From: Simon Davis
Sent: 28 March 2019 09:13
To: Planning.Responses
Subject: FW: BN/50/18/PL The Fallows

Further Drainage Comments.

From: Laura Gibbons
Sent: 28 March 2019 08:52
To: Simon Davis <Simon.Davis@arun.gov.uk>
Subject: RE: BN/50/18/PL The Fallows

Drawing 23B – SW Drainage Plan
Scale 1:200 @ A3

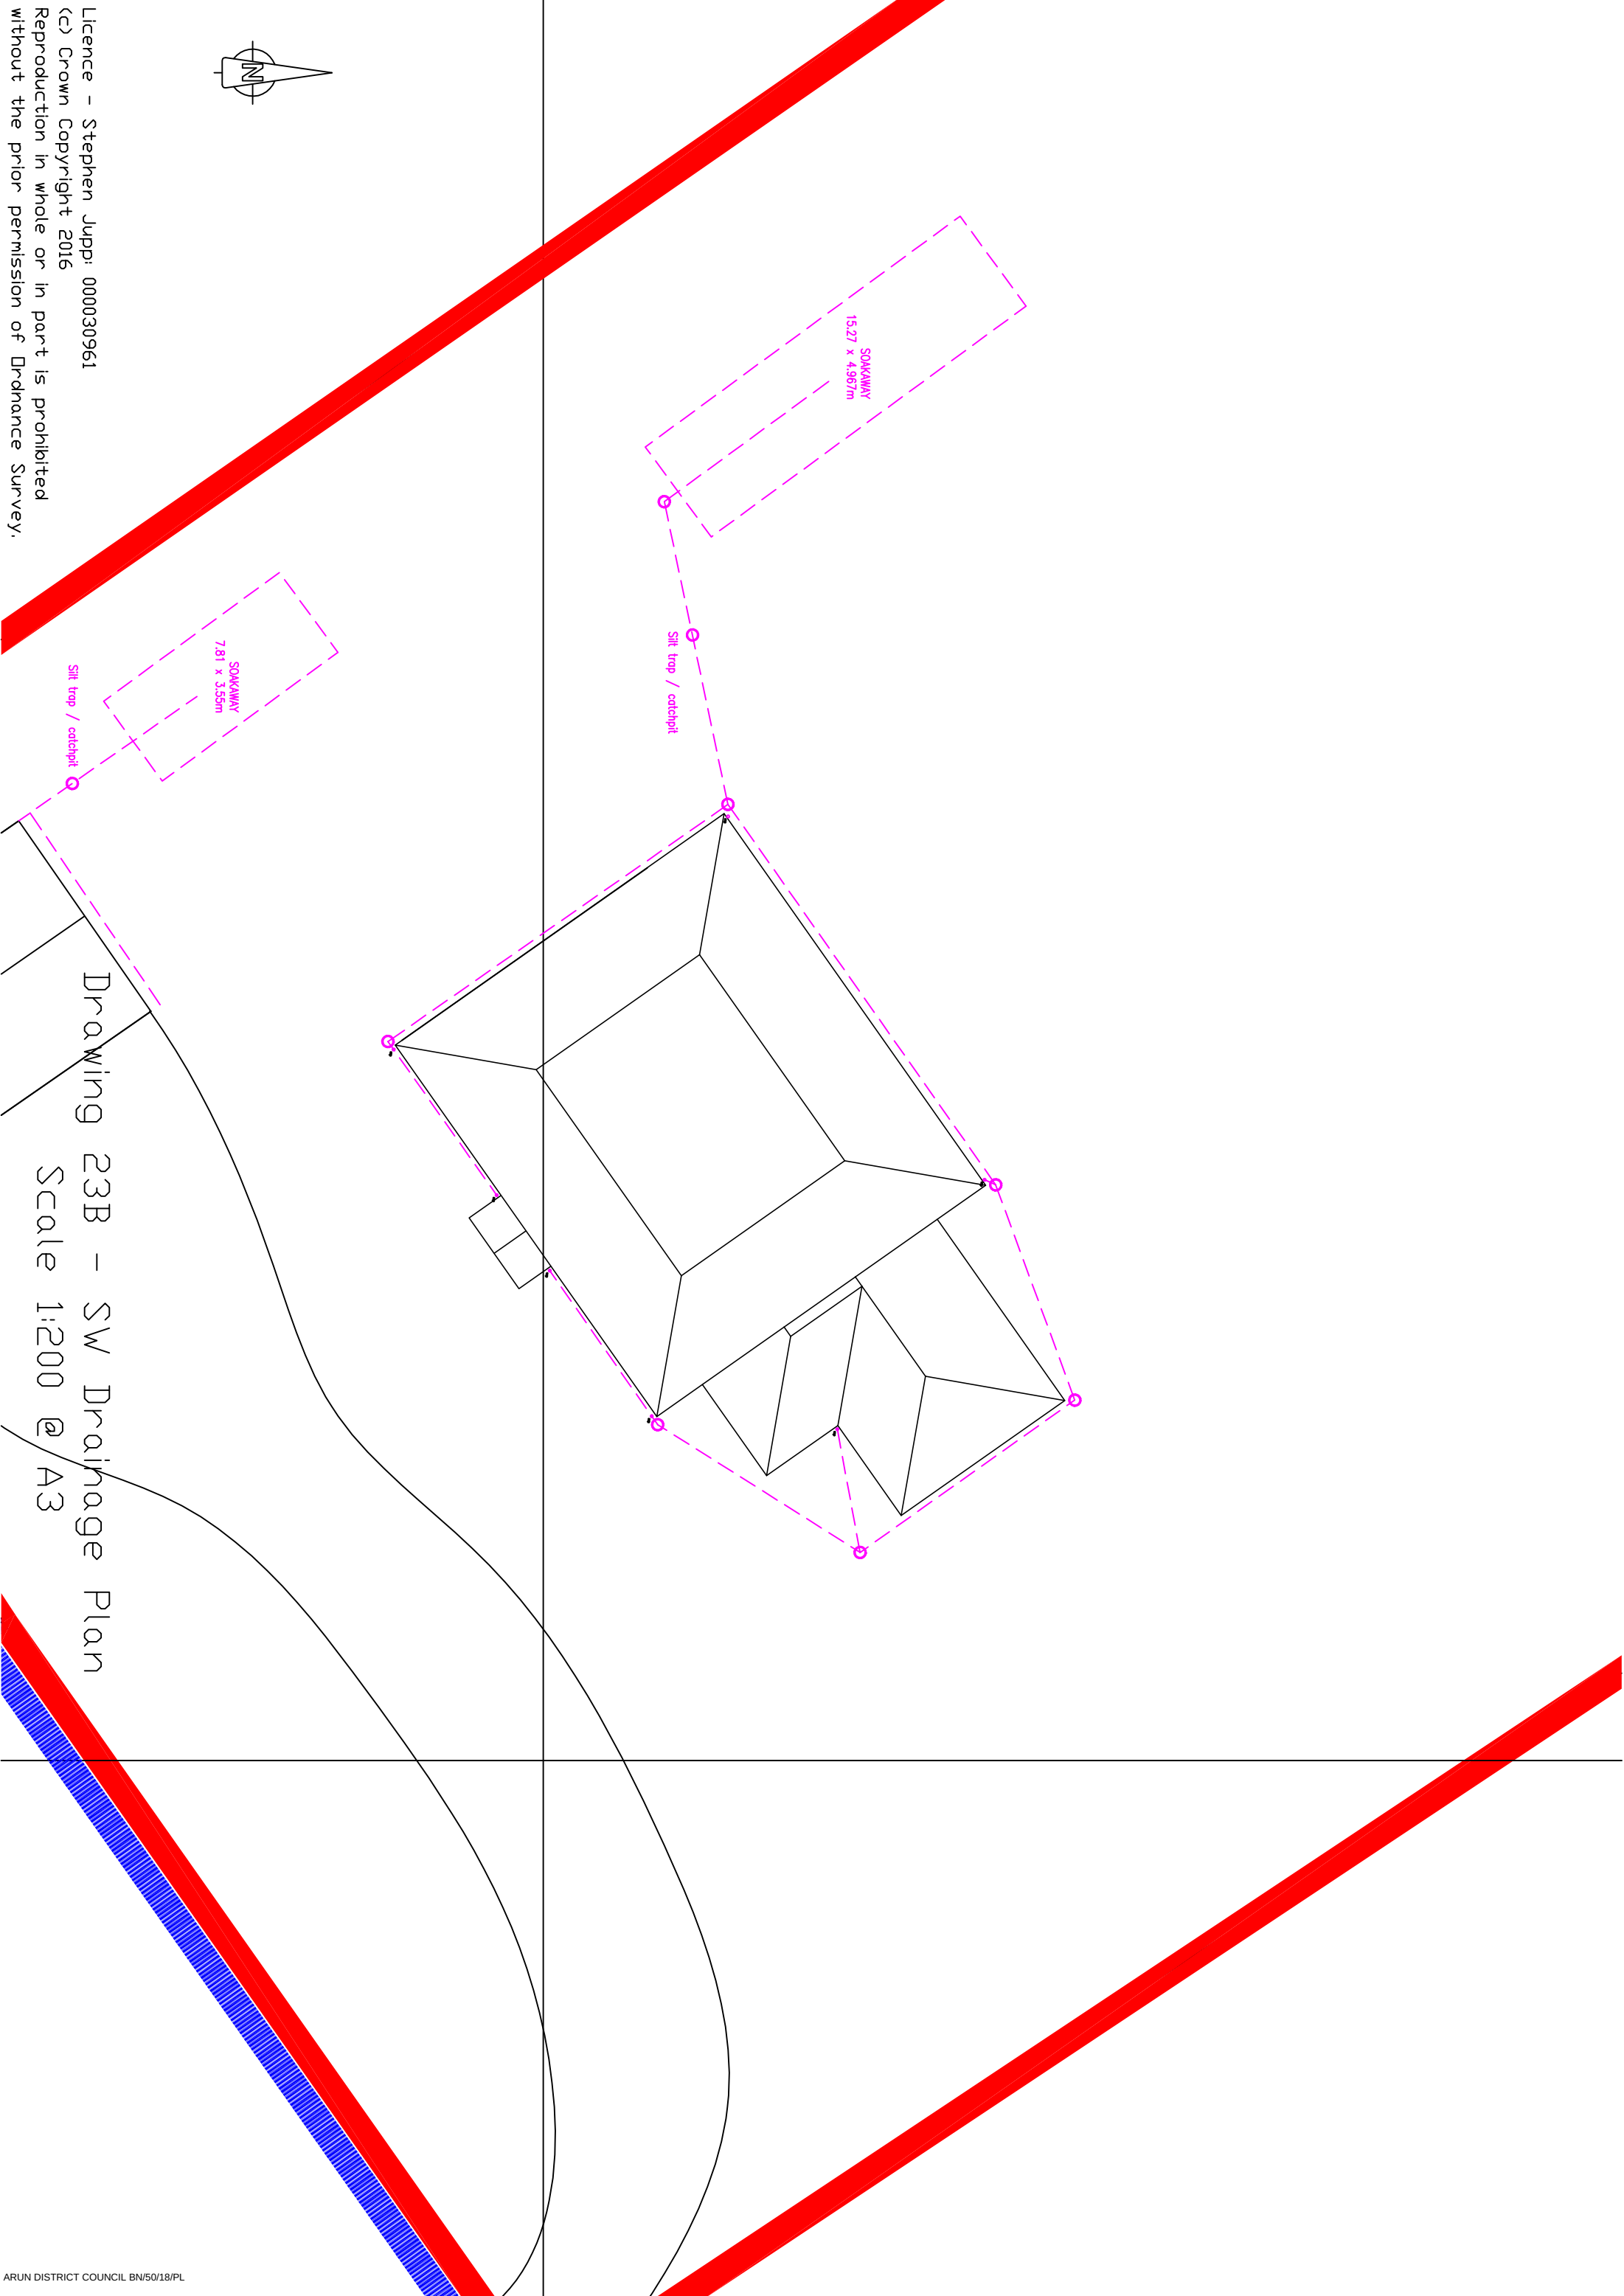
I note that calculations for two soakaways are provided, yet only one is shown on the layout plan. Please ensure that layout plans meet calculation requirements.

I did not explicitly state previously our requirements for the layout plan, as I presumed the applicant would look at our checklist. The layout plan needs to be updated to ensure that it includes:

- All surface water drainage pipes labelled with; diameters, pipe materials, falls and invert levels.
- All infiltrating structures (including permeable paving) labelled with; dimensions, invert and cover levels.
- All manholes labelled with; cover levels, invert levels, cover types detailed.
- All silt traps clearly labelled with sump depths.
